From: Sue Howell <Sue.Howell@arun.gov.uk>
Sent: 16 December 2019 14:04
To: Sue Howell <Sue.Howell@arun.gov.uk>
Subject: RE: Planning Consultation on WA/95/19/DOC

Further comment from Greenspace - Revision to location of proposed golf netting

APPLICATION NO: WA/95/19/DOC

Description of Works: Approval of details reserved by condition imposed under ref WA/95/18/RES relating to Condition No 5 - golf mitigation

Project	Land East of Tye Lane, Walberton		
Title	Golf Course Netting Indicative Detail		
Client	Linden Homes		
Scale	1:100 @ A3	Drawn	AL
Date	Sept 2019	Checked	GC
Drawing No.	CSA/3823/119	Rev	B

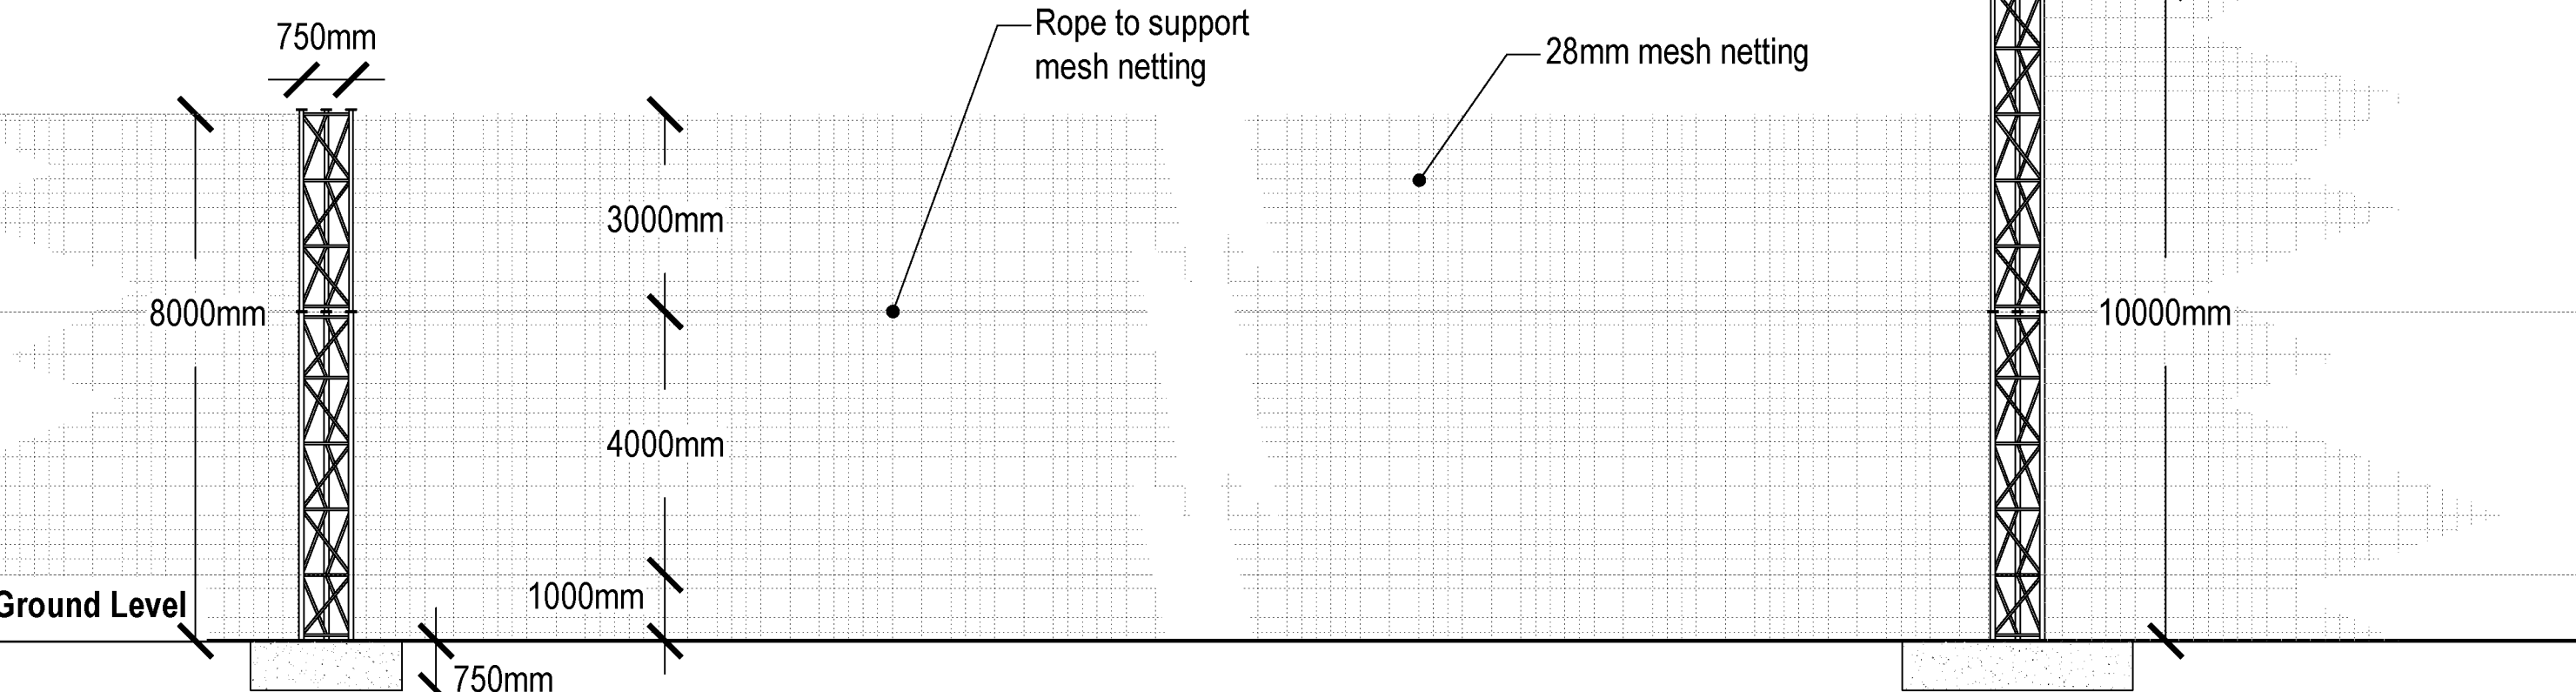
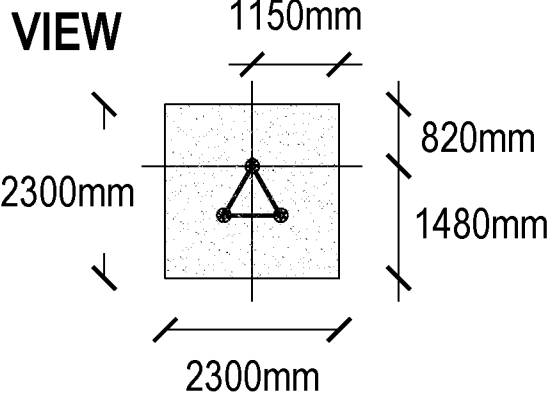
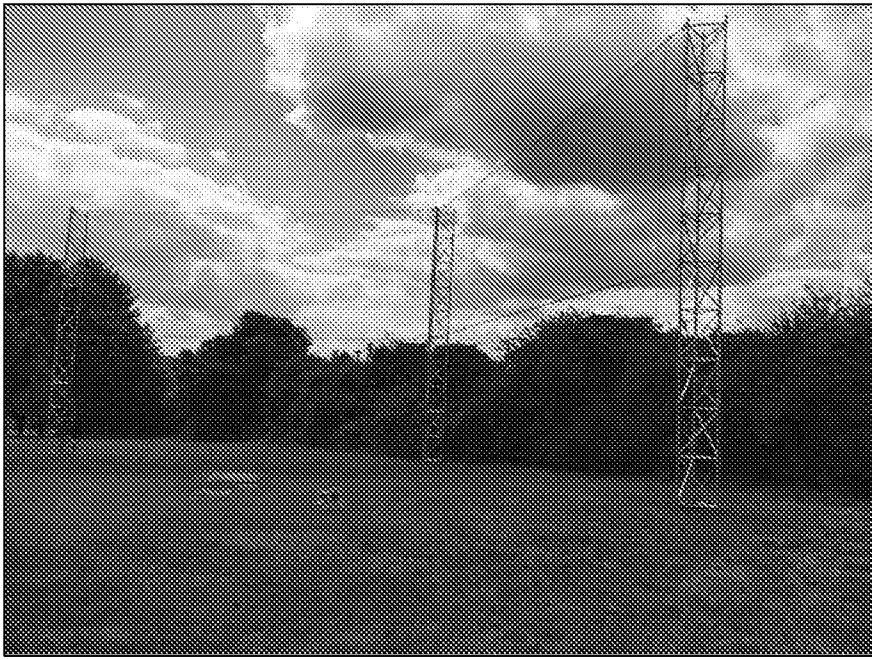
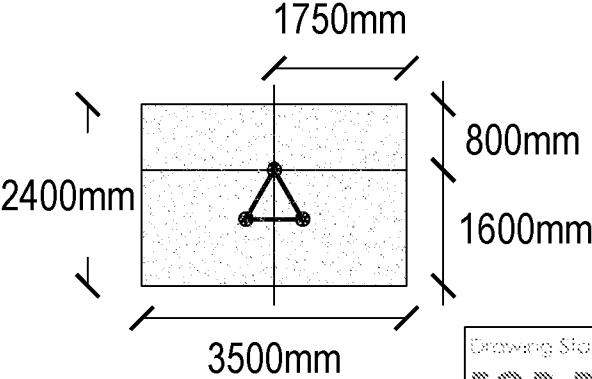
Further to submission of Landscape revision specifically re Golf Course Netting Details and positioning of same and now contained in Dwg Sept 19 GNL.01 Rev C Proposed Golf netting Location now staggered and location **and in consideration of swale location**, amended and CSA/3823/119 and associated Soft landscape proposals dwgs CSA/3823 101-103 **REV G, G & J** CSA/2823/107-110 I can confirm that the information supplied proposes a scheme for the purpose of offsetting any on-site or offsite mitigation measures to minimise the ingress of golf balls onto the site, along with a landscape proposal which over time should minimise the visual impact of these measures. The thicket planting is to be planted golf course side of the development, but as this establishes it will be seen through the netting and form a green screen of varying height and thickness.

The detail of the ball stop netting adjacent to the golf course, has a planting proposal which whilst would not disguise it, will go somewhere over time to softening the impact of this –however not to the full height 10m of the fencing proposed. I confirm that I would see a visual improvement in the staggering of the fencing now 6-10 metres The visual impact of these measures along this boundary should be noted. There has been the inclusion of mature tree planting in this location which has a greater opportunity as it establishes to detract the eye, whilst allowing important views through to the golf course beyond.

The fencing will need to be maintained in good condition thereafter in order for the purpose of this to be realised.
